**Ref No:** F2020/00664

Application No: SSD-10822510

**Re: Randwick City Council submission on the State Significant Development SSD-10822510 – UNSW Health Translation Hub (SSD-10822510)**

Level 08	
scale	1 : 250@A1
drawn	TH
checked	JC
project no	190551.00
drawing no.	DA1009
issue	D

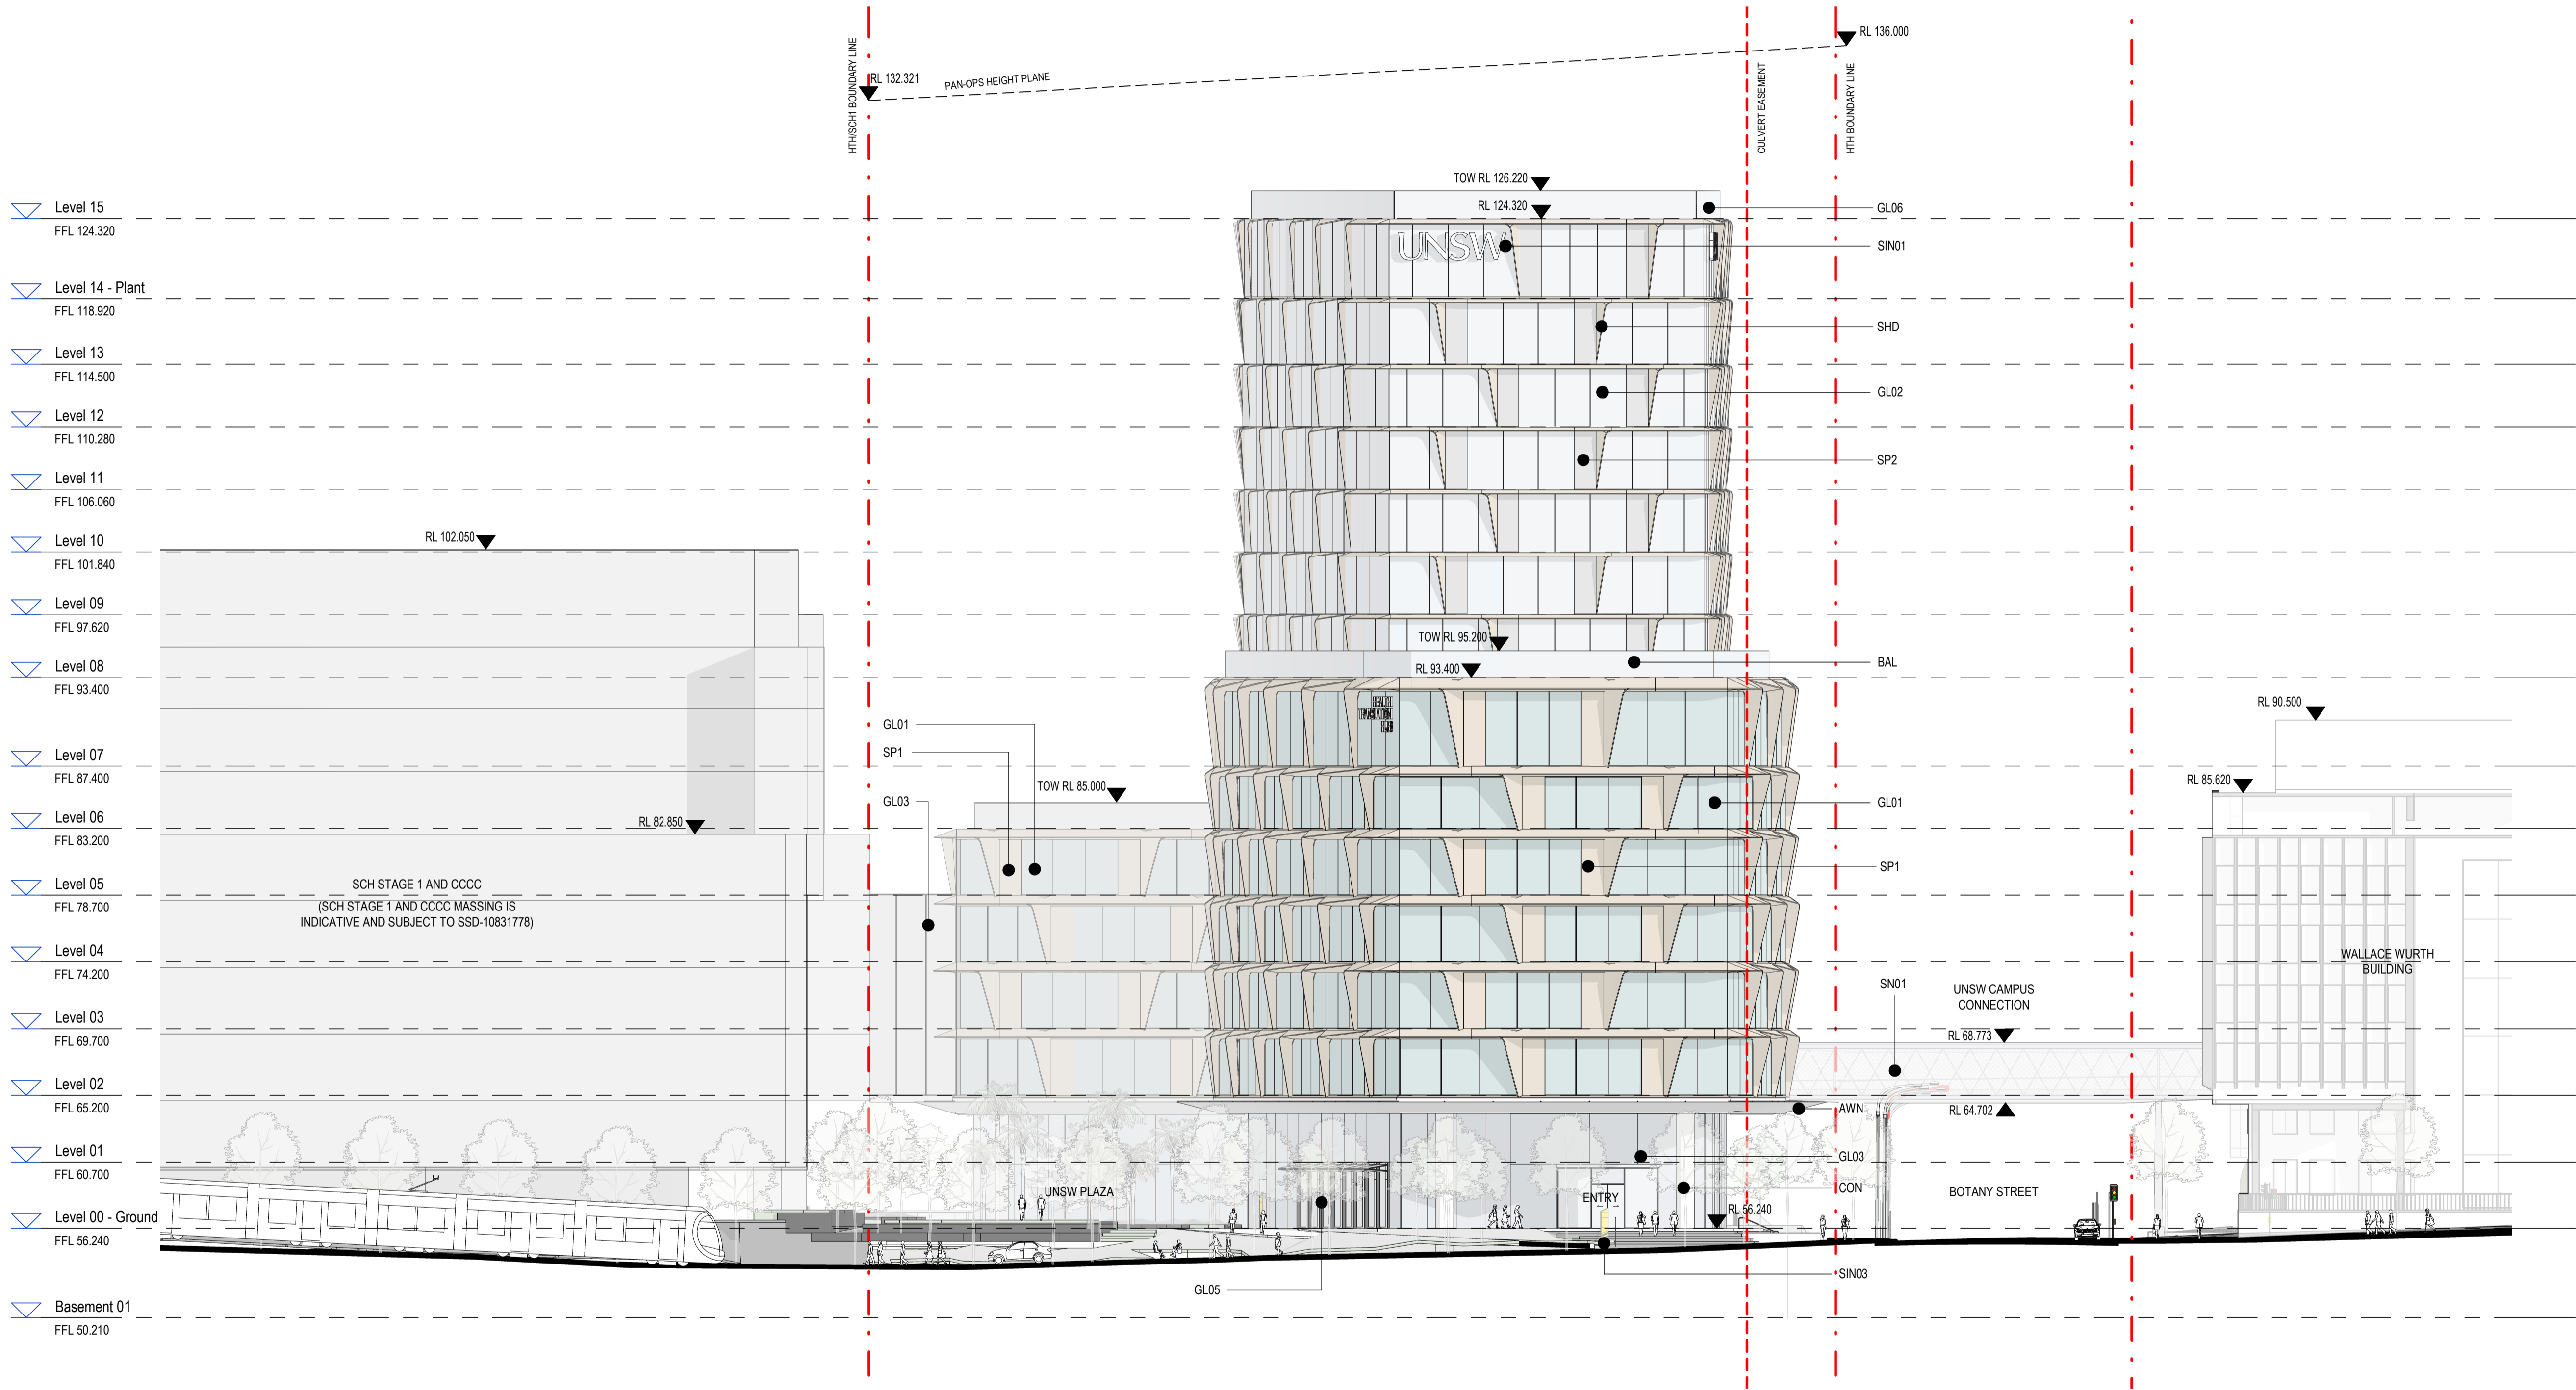
26. Further landscape detail is required for the proposed roof level and upper level terraces. The podium roof areas should be utilised to provide outdoor landscaped terraces areas for workers and visitors where possible.

Independent Ground Floor Plan		
scale	1 : 250@A1	drawing no.
drawn	TH	DA9101
checked	JC	issue
project no	190551.00	B

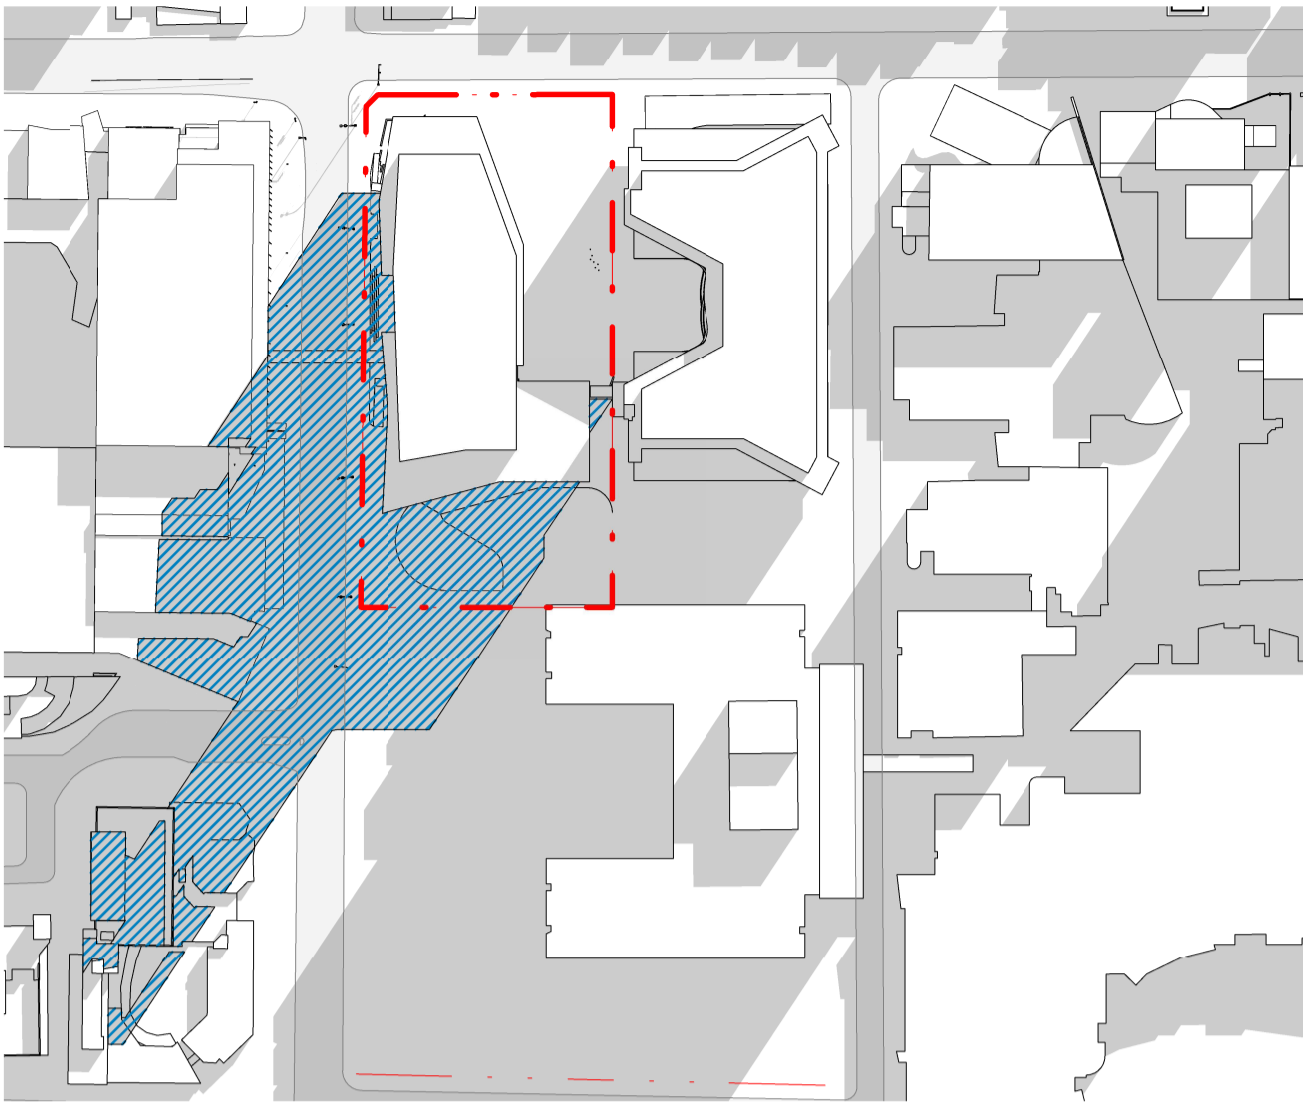
16. The creation of an indented parking bay for the 'Pick Up / Drop Off (PUDO) task along Botany Street is not supported. Along a 55m length of 1 hour parking, the creation of a PUDO bay affords no benefit. Indeed, the creation of the proposed PUDO actually reduces parking efficiency due to the required angled transition from the existing kerb line to the recessed kerb line. Council recommends simply signposting the PUDO area while maintaining the existing shared path and providing the opportunity to continue some low level Botany Street landscaping elements. This signposted area will accommodate the PUDO task and have the adjacent shared path maintained at full width. In addition, a 'signposting only' solution provides flexibility to increase (or decrease) the length of the PUDO zone in the future, depending on demand over time.
